STATE OF COLORADO
DEPARTMENT OF TRANSPORTATION
CITY OF COLORADO SPRINGS
Parks, Recreation and Cultural Services Department
CAPITAL IMPROVEMENT PROJECT
TRAIL IMPROVEMENT PROGRAM
COMBINED FEDERAL AID PROJECT No. TAP M240-162, SubAccT. No.20391

GRADING AND EROSION CONTROL

PLAN of the ROCK ISLAND MULTI-USE TRAIL
SAND CREEK TO CONSTITUTION AVENUE COLORADO
SPRINGS & EL PASO COUNTY, COLORADO

8 March 2024

Kiowa Proj. No. 16028	
TAP M240-162	
SubAcct No.20391	
Sheet Number	GEC4

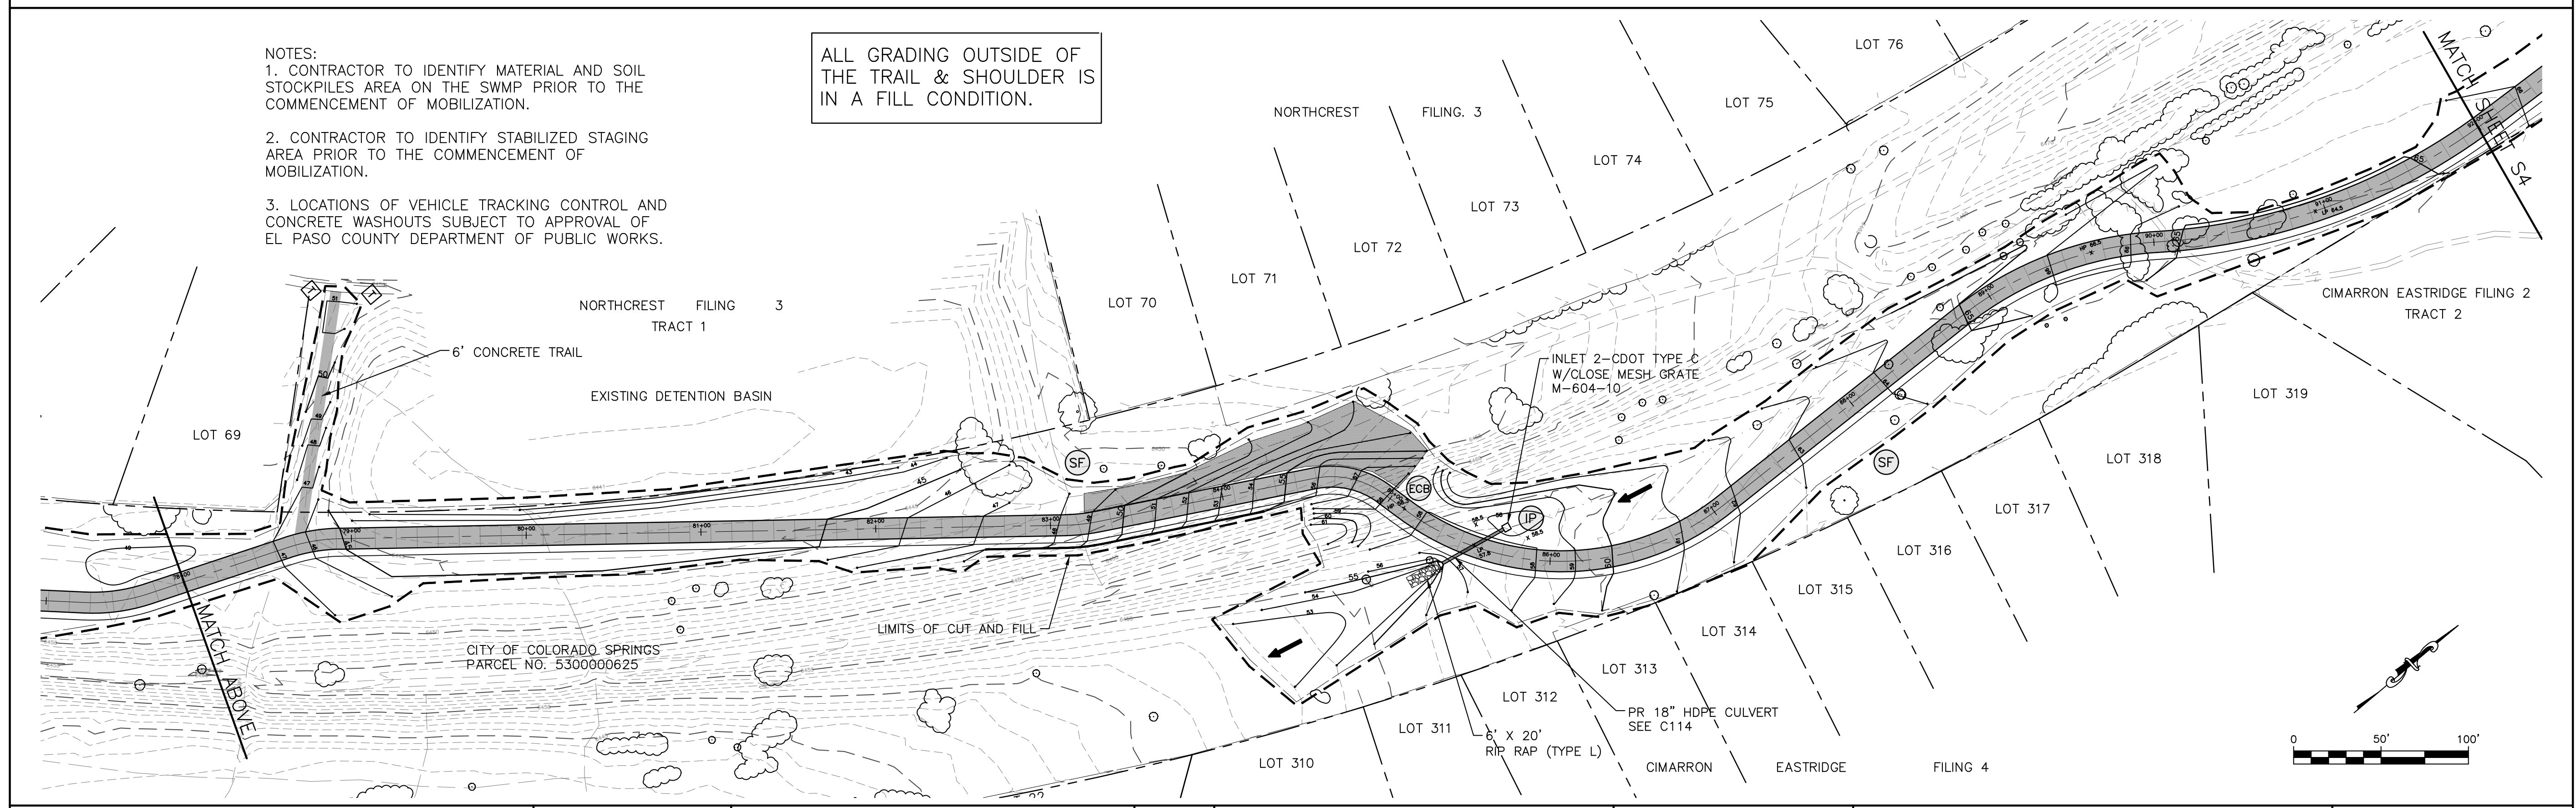
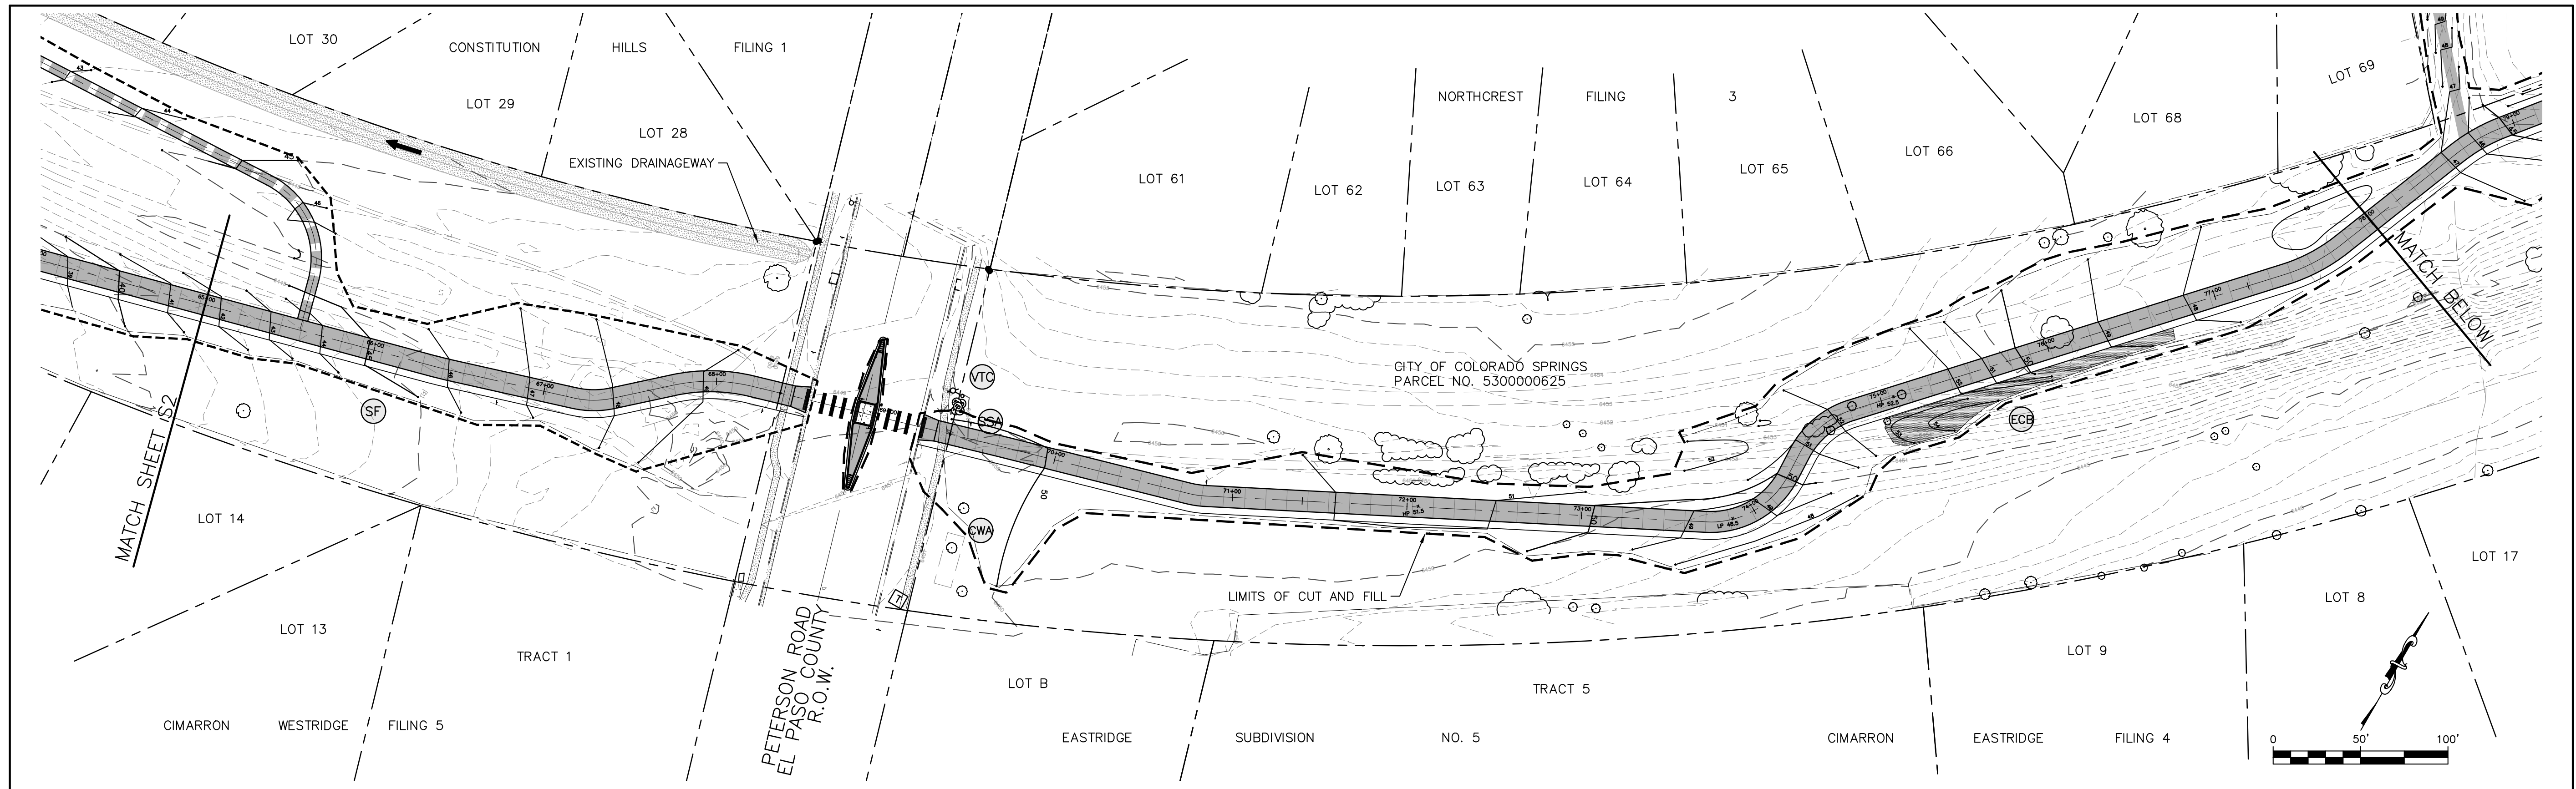
This existing contours don't appear to be very channelized, will there be any erosion issues with the concentrated flows? Is there any way to allow the runoff to sheet flow?

outlet protection?

Kiowa Proj. No. 16028
 TAP M240-162
 SubAcct No.20391
 Sheet Number **GEC5**

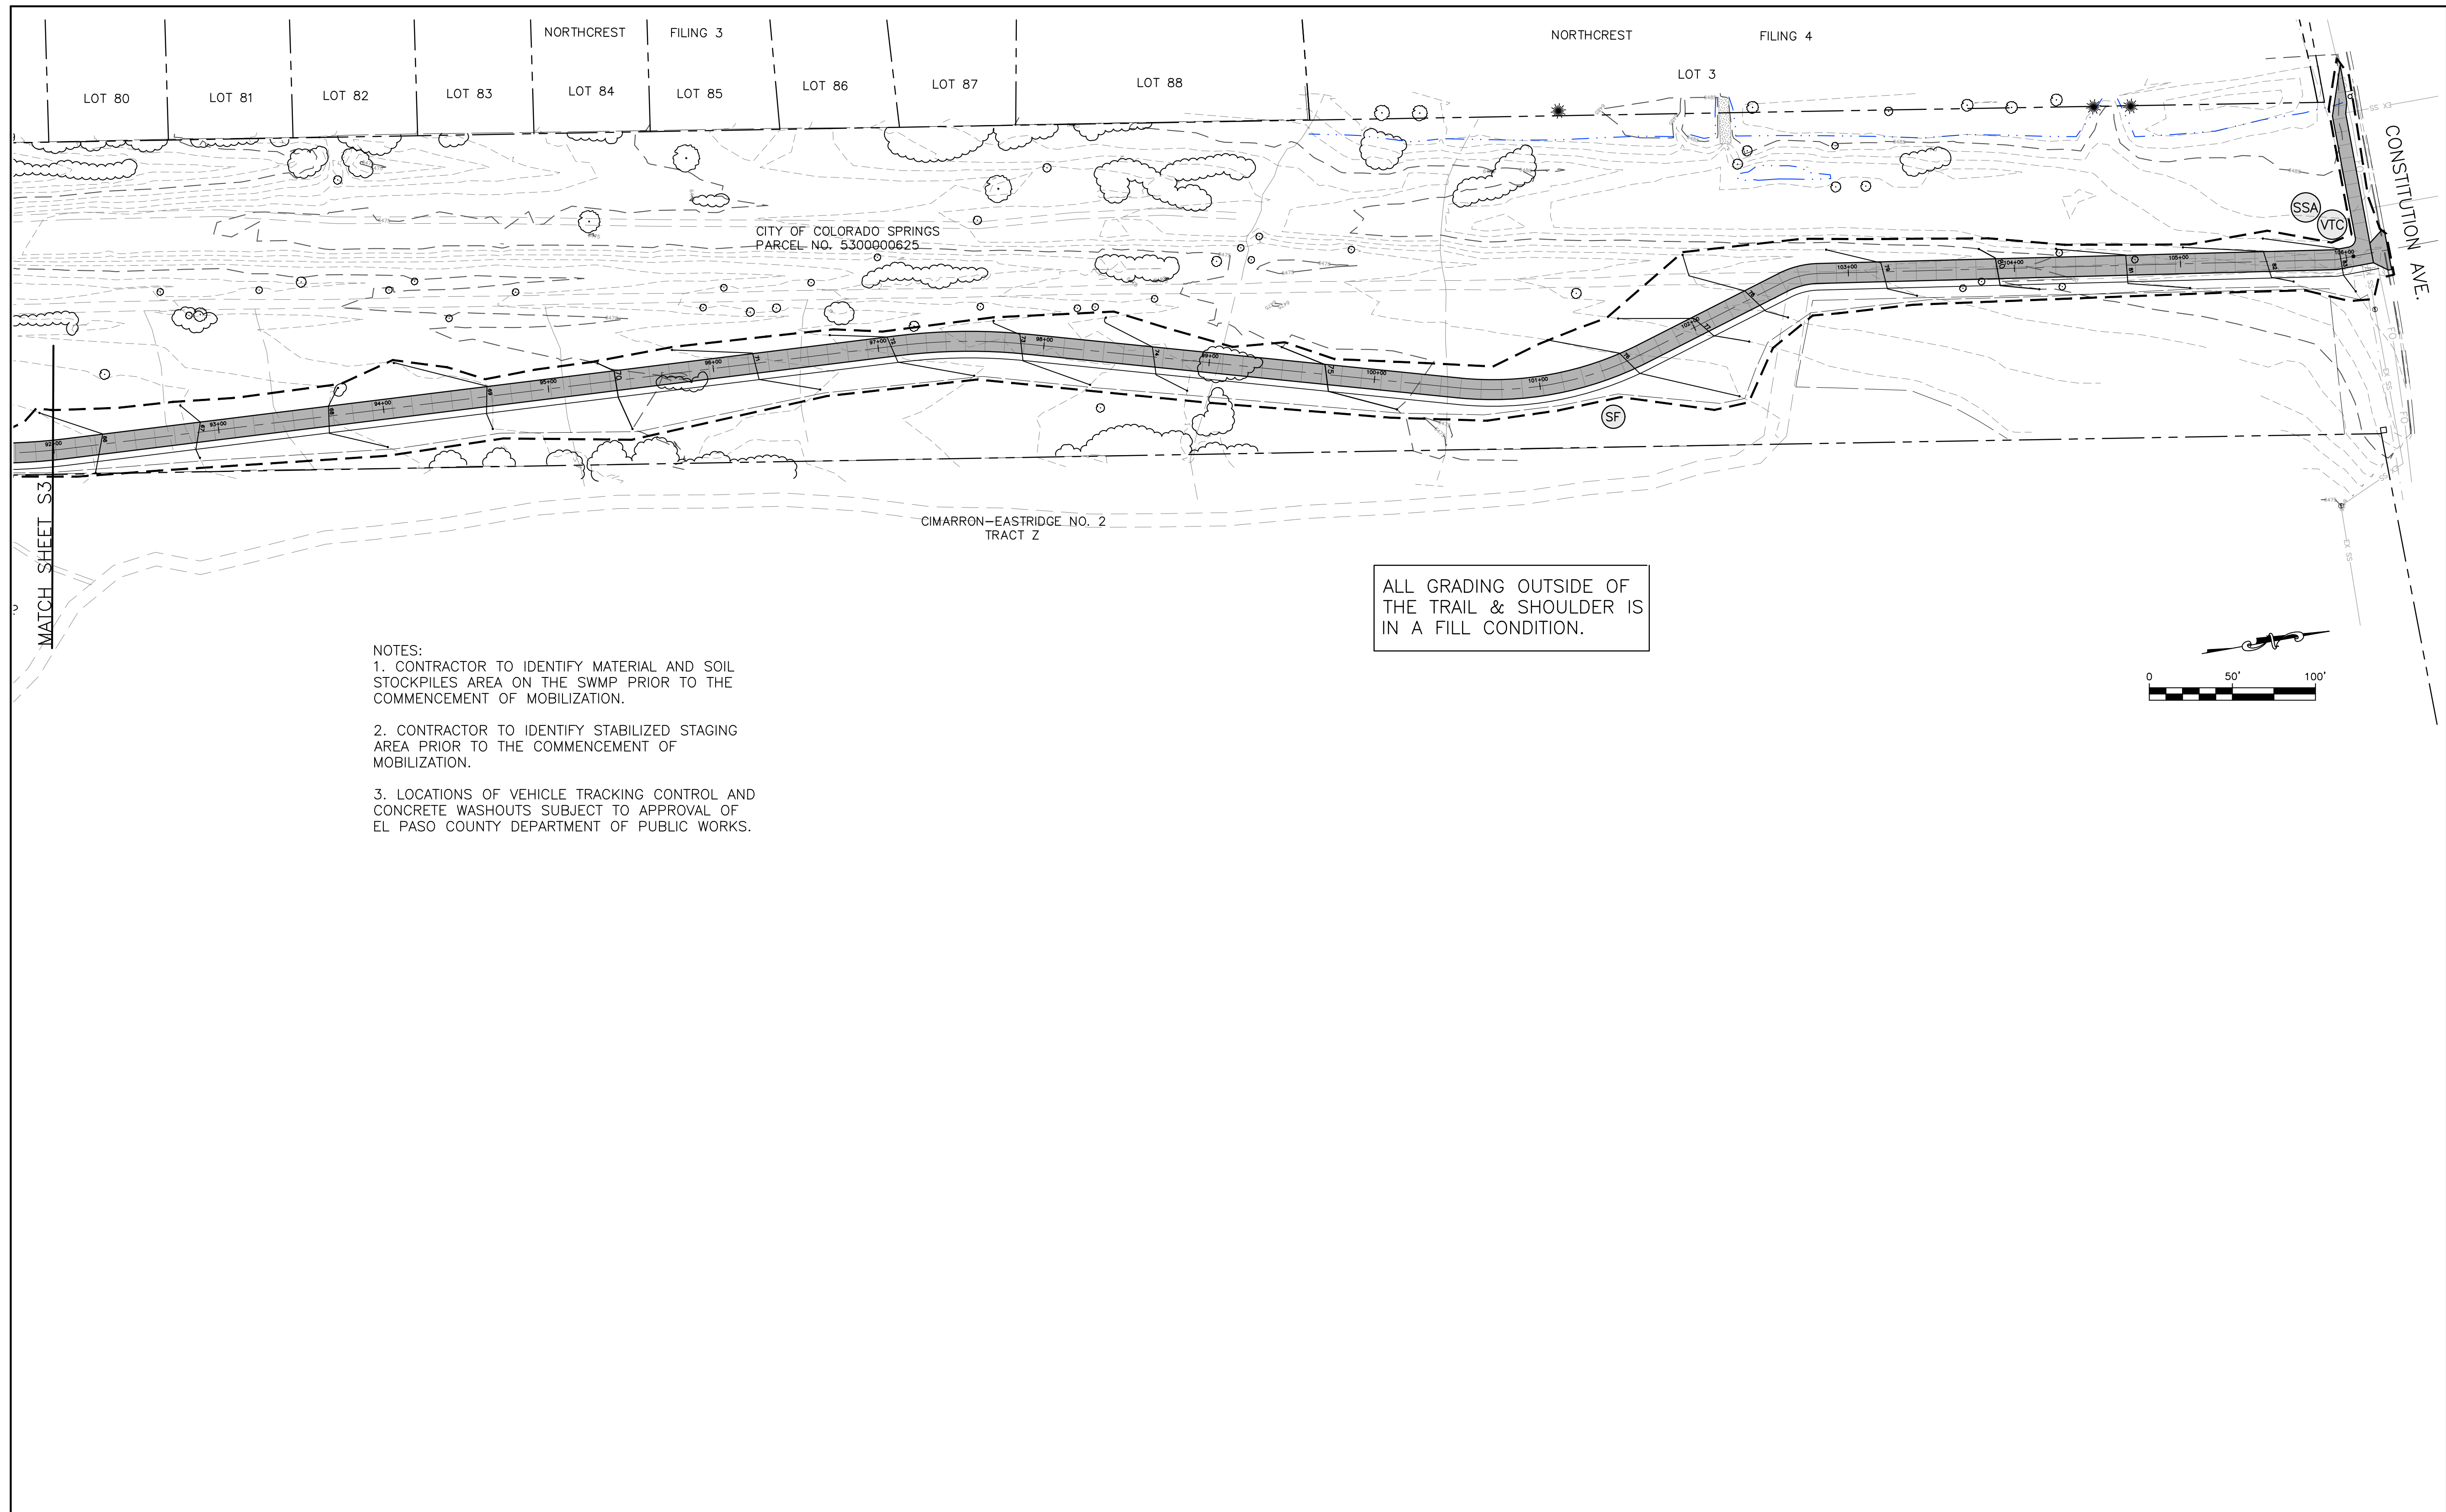
Show rough limits for staging area so it is accounted for in the LOD even if it may change/move during construction.
